6-28-01 spoke w/owner about code requirements +  
required Inspections (16)

CBL# 141-C-22  
permit# 01-0695

11'4" Floor Plan

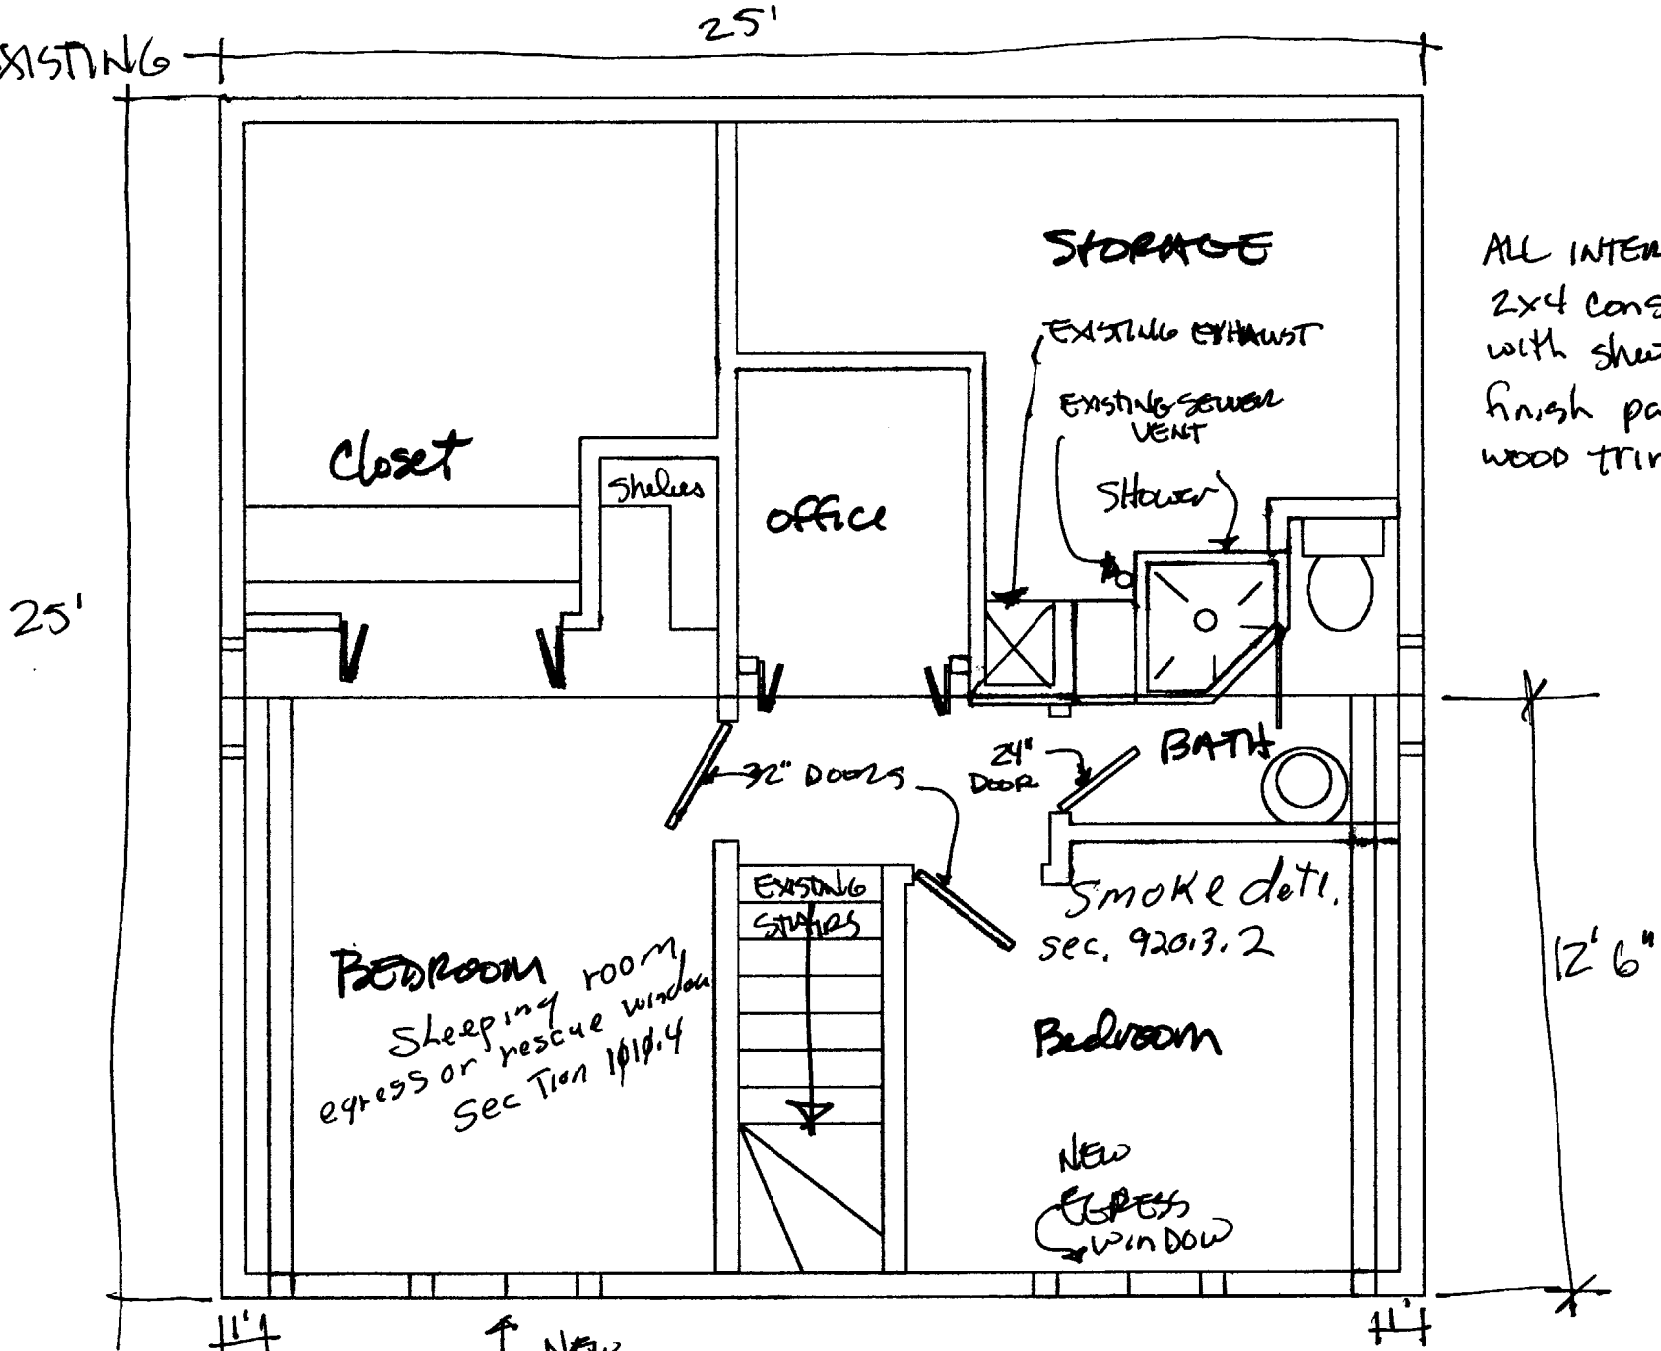
9/13/01 Close in insp w/elect/plumb. Egress ok -  
New LVL for Ridge w/Joist all on hangers. ok to  
close JB

11/08/01. Final inspection on finished dormer -  
Egress OK. Construction quality good - no issues.

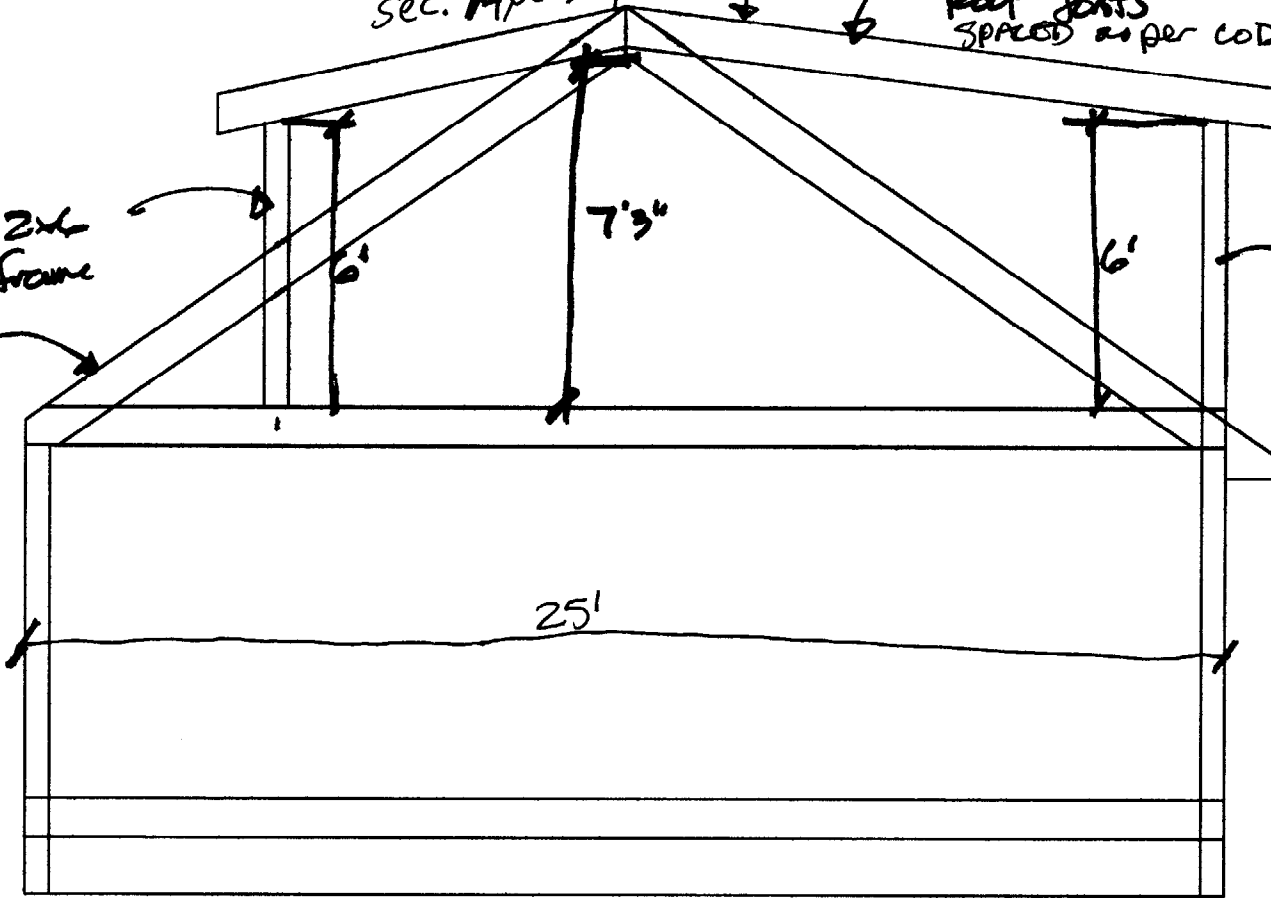
8/22/01 pre-con w/owner about specific requirements  
stated on permit. Smokes, Egress windows, bridging  
and Roofing. Reviewed inspection call for close in. JB
